**ADC Planning Consultation  
Response from the Conservation Officer**

| <b>Application Number</b> | BR/240/14/PL                                                            |
| <b>Address</b>            | The Claremont Scott Street Bognor Regis PO21 1UH                        |
| <b>Description</b>        | Front and side elevation window alterations from PVCu to hardwood pine. |

Proposed Elevations

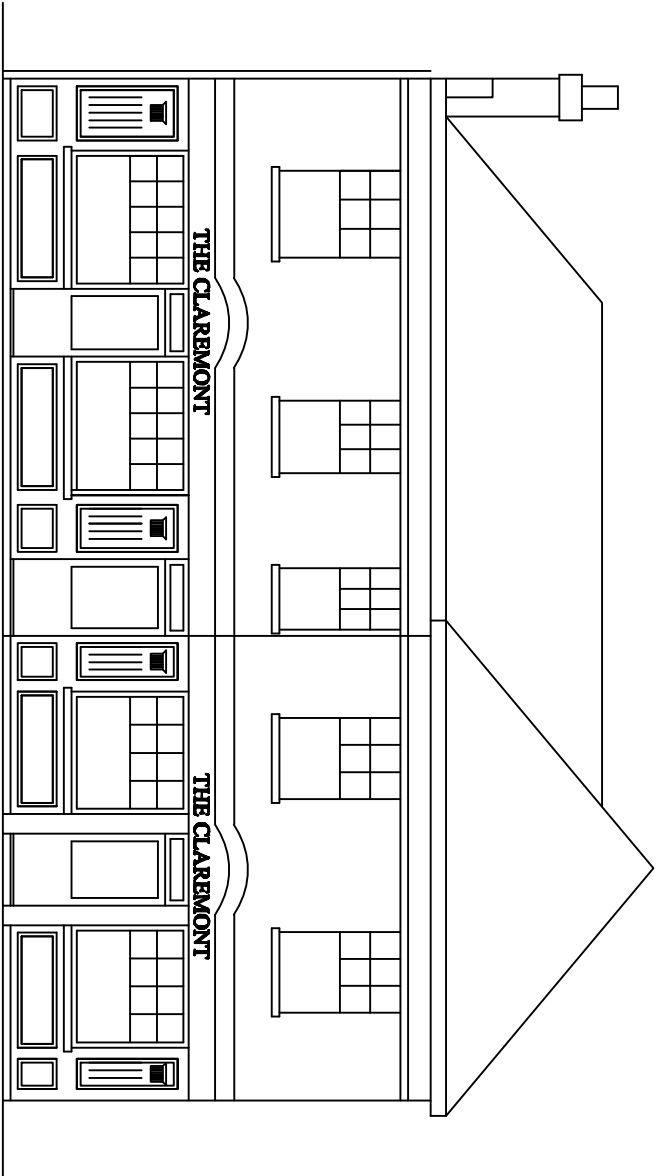
However, certain issues need to be clarified; the proposed elevation drawing conflicts with the proposed picture elevation in certain instances. If minded to approved, it is suggested that more detailed window details and colours are provided by condition.
